Environmental Health Consultation Response

To	Mrs D Johnson
Date	13-07-2026
Planning Ref	BR/102/26/A
Site Description	42 High Street Bognor Regis West Sussex PO21 1SP
Date of Application	2026-06-03 00:00:00
Category	Application
Recommendation	No Objection No Objection – with conditions Objection Holding Objection

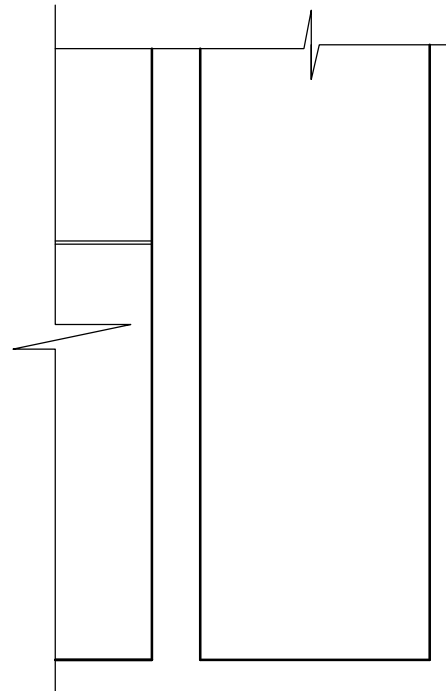
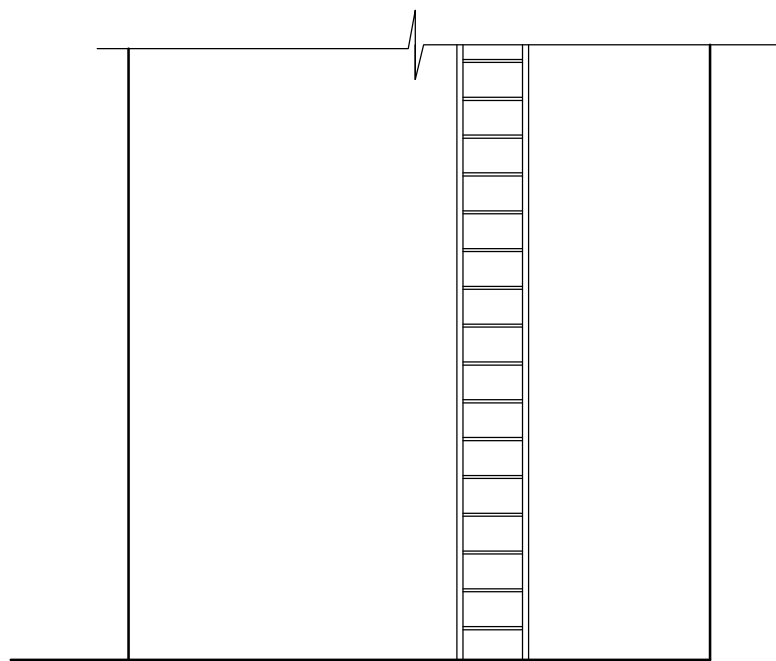
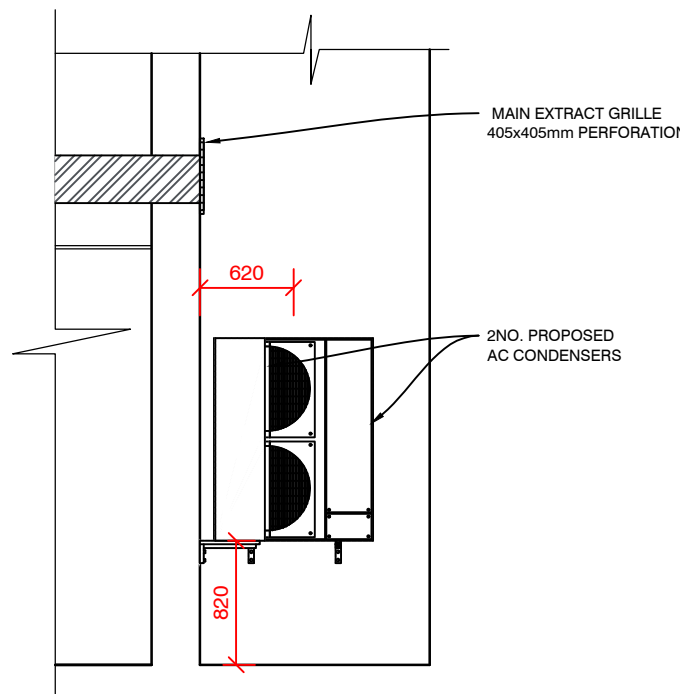
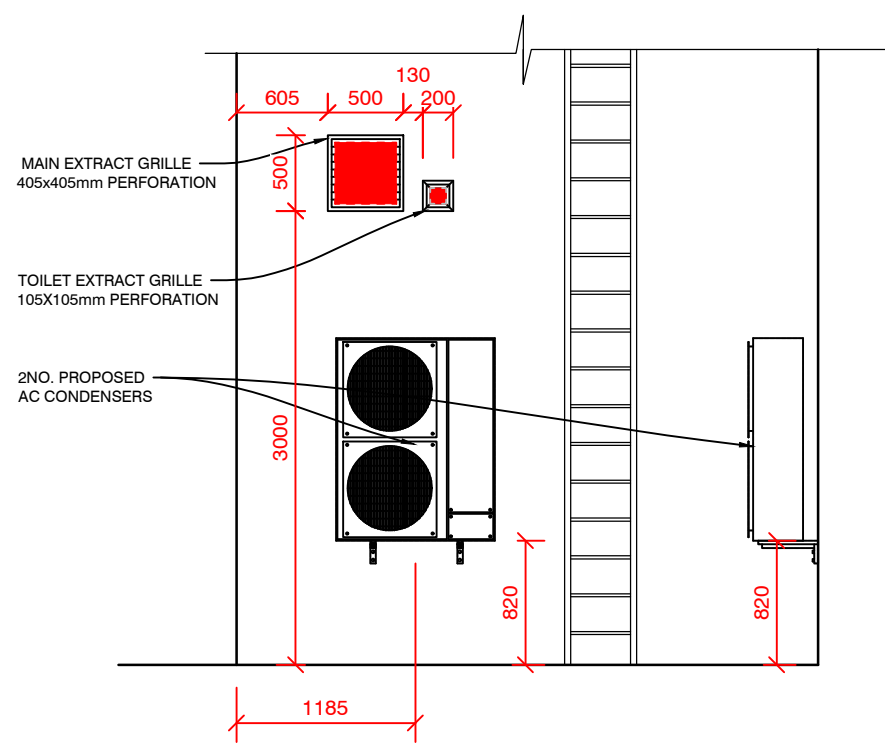
EH Comments: Eh concern relates to noise generated by the plant, not the advertisements or shopfront. The applicant should submit noise data for the plant.

EHN23 : Building services plant (BS4142:2014+A1:2019)
EH - see notes

No internally or externally located plant, machinery equipment or building services plant shall be operated on the site until an assessment of the acoustic impact arising from the operation of all such equipment has been submitted to and approved in writing by the Local Planning Authority. The assessment shall be undertaken in accordance with BS 4142:2014+A1:2019 and shall include a scheme of attenuation measures to mitigate the adverse impacts identified in the acoustic assessment. The scheme shall ensure that the rating level of noise emitted from the proposed building services plant is 5 dB less than the prevailing background sound level (LA90). The scheme as approved by the Local Planning Authority shall be fully installed prior to first operation of the plant and shall be retained as such thereafter. Any agreed attenuation measures shall be permanently maintained in good working condition.
